MAJOR DEVELOPMENT PLAN AMENDMENT

PART W 1/2 SEC 1, T 13 S, R 65 W, 6th PM FALCON, COLORADO

COVER SHEET
NEW RV STORAGE FOR:
FALCON STORAGE
PART W 1/2 SEC 1, T 13 S, R 65 W, 6th PM
PEYTON, COLORADO

SHEET
SDP1.1

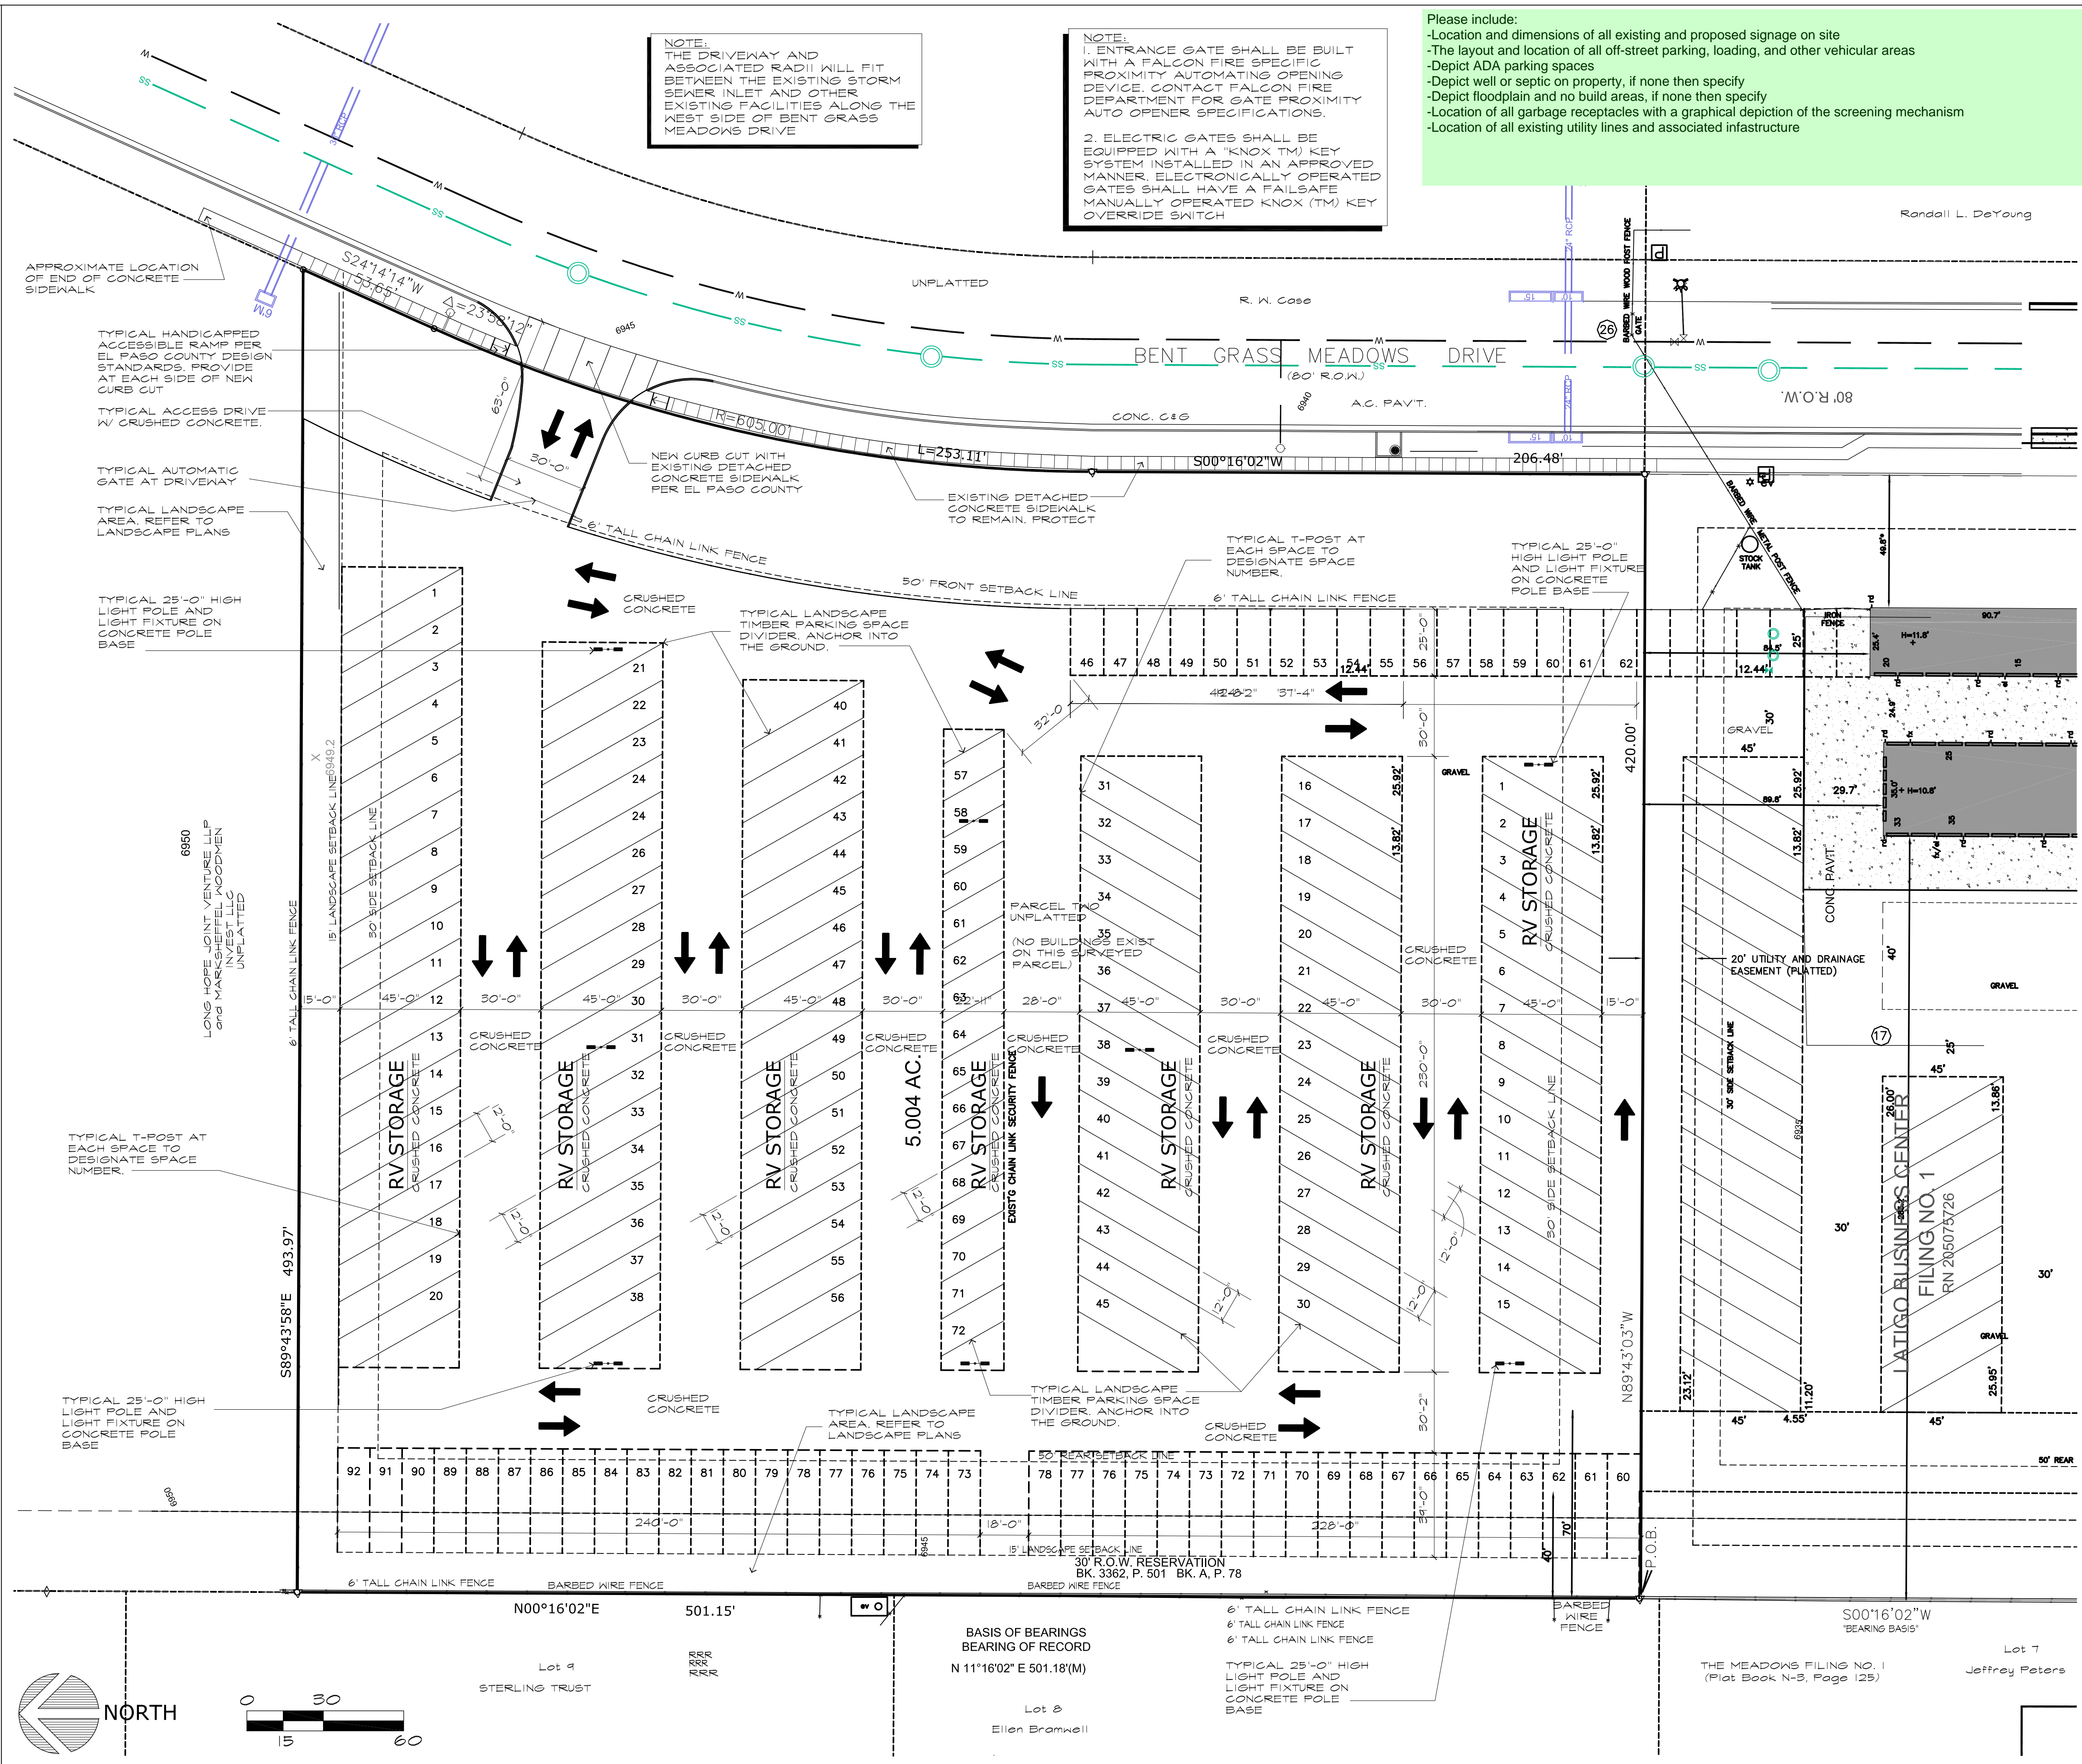
Review 1 comment:
Please identify the setbacks required from Bent Grass Meadows Drive

Review 2: unresolved

review 1: please update the schedule
review 2: unresolved

Please provide:
-total gross building square footage
-open space, landscaping, and impermeable surface percentage
-parking computations

1"=40'  
INTERIM CONDITION DURING CONSTRUCTION TO BE CONVERTED TO SAND FILTER BASIN

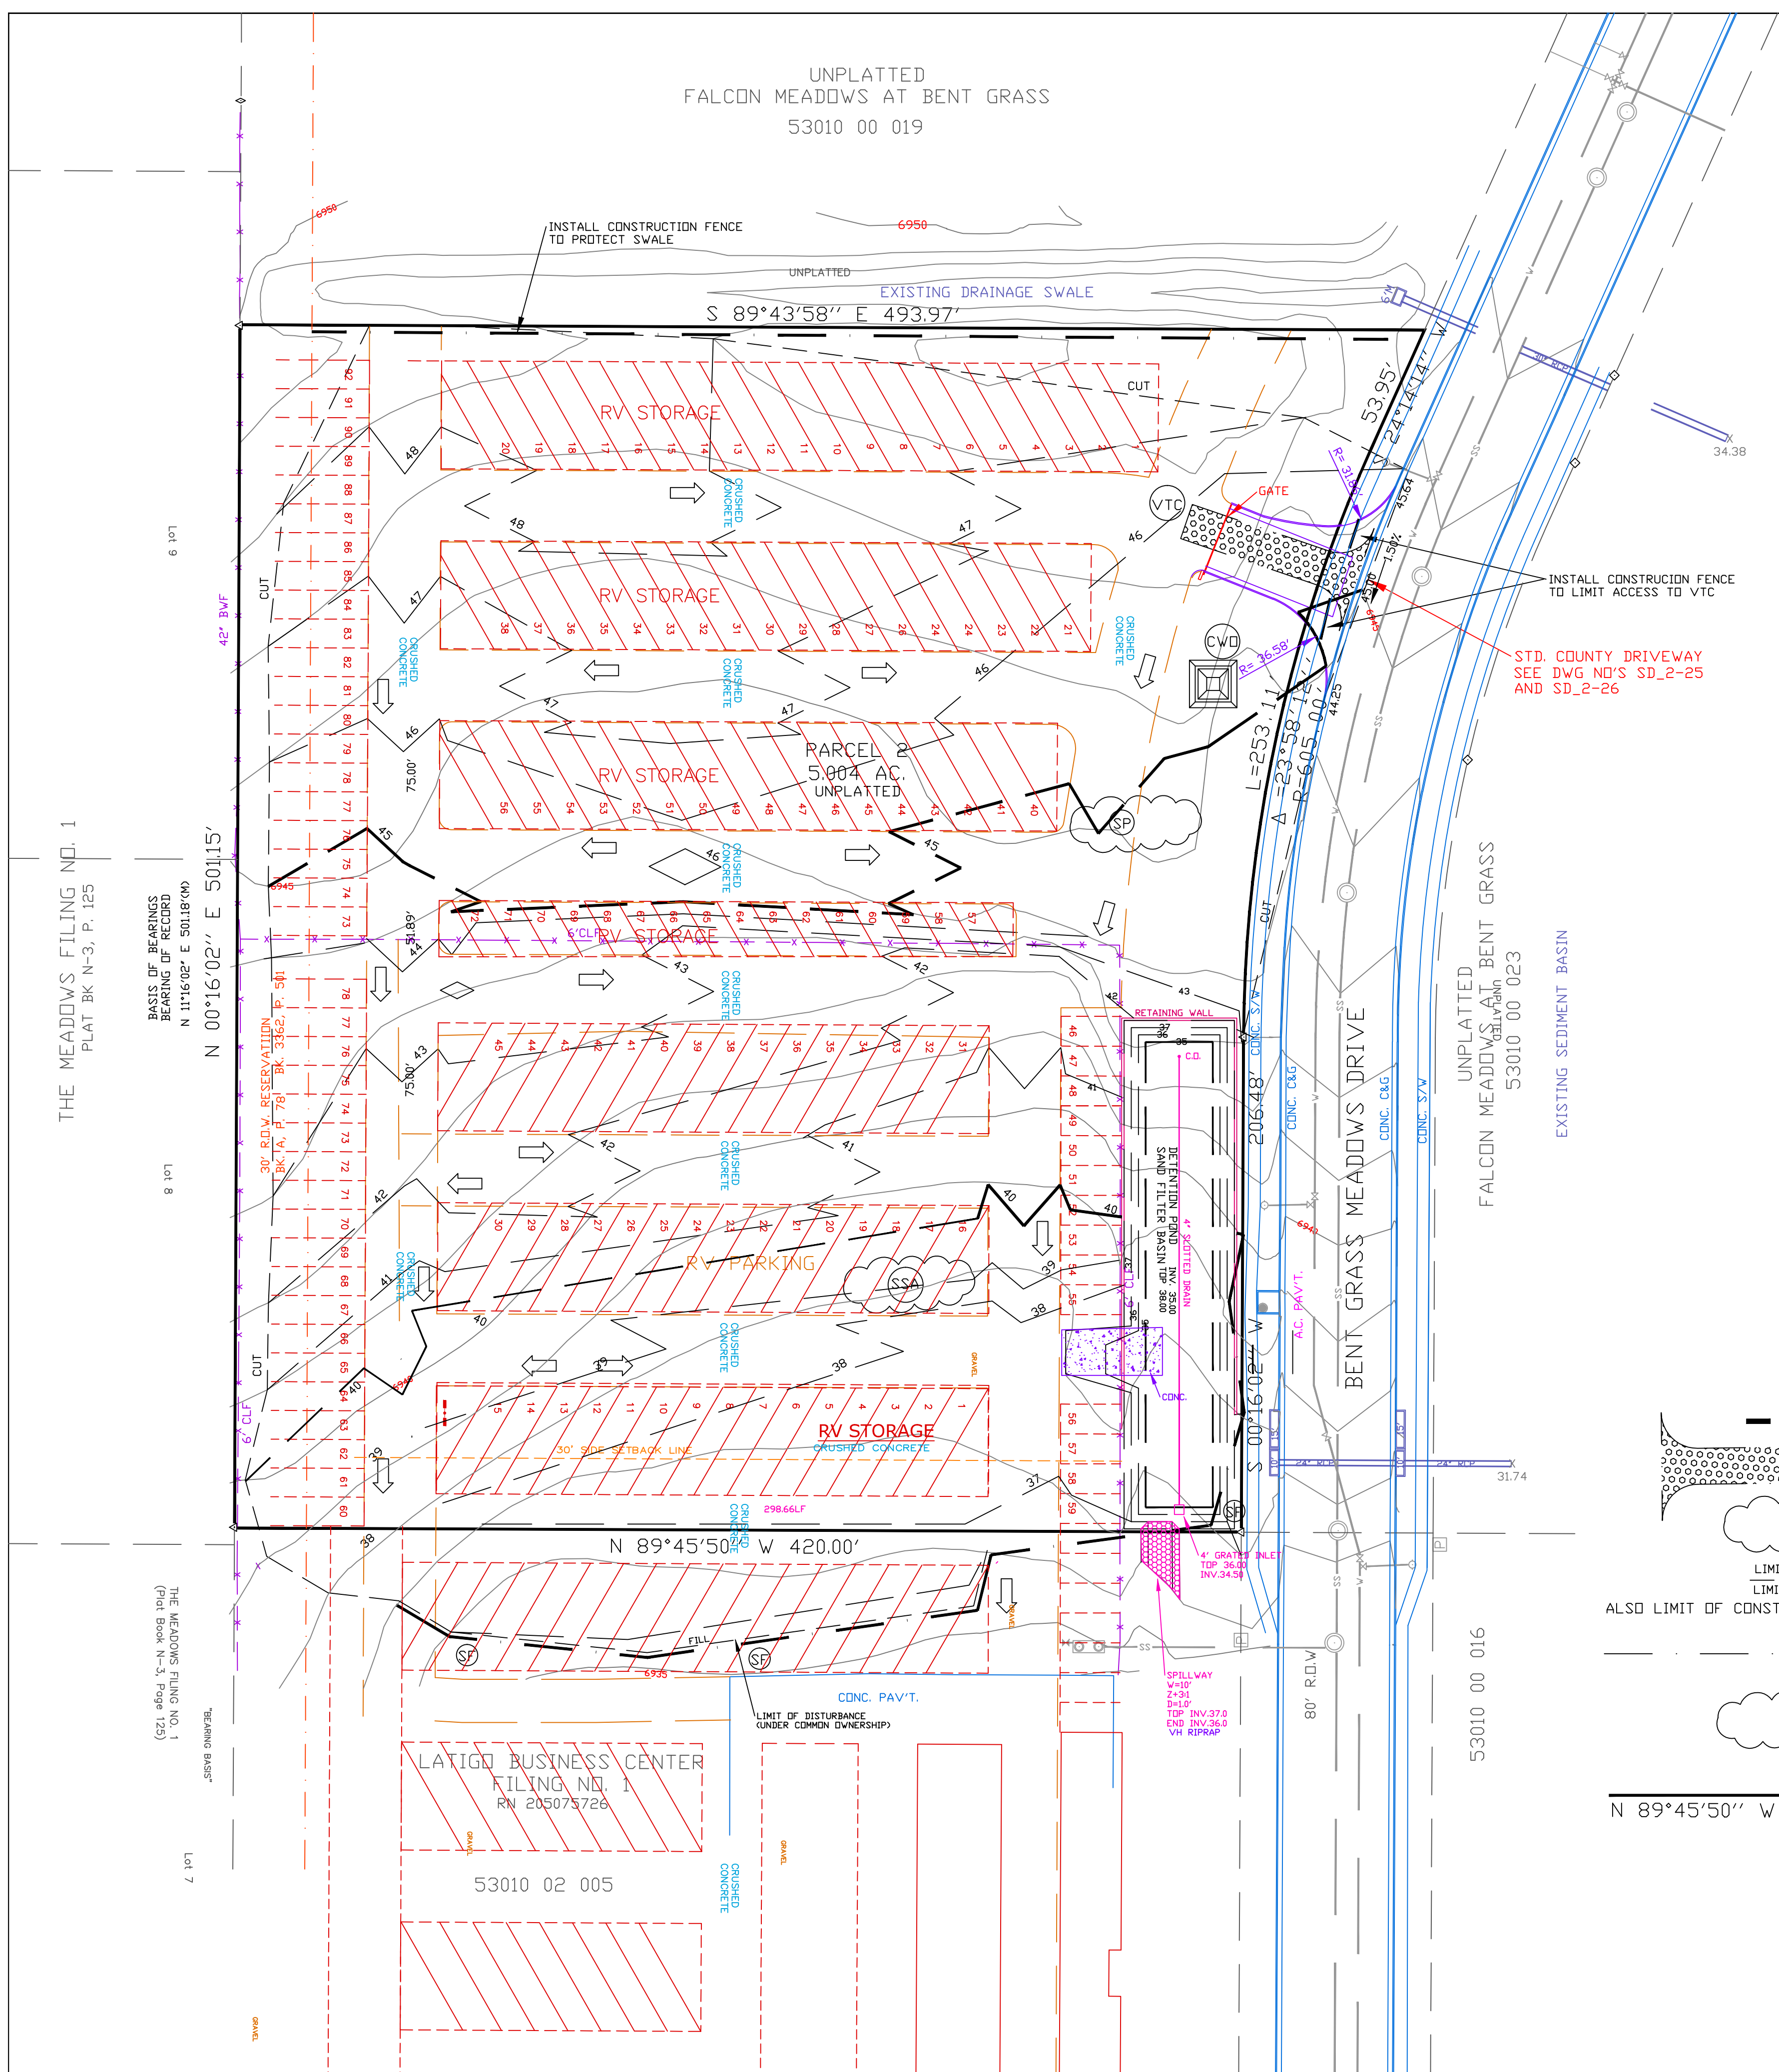
comments have been provided on the stand alone GEC plan
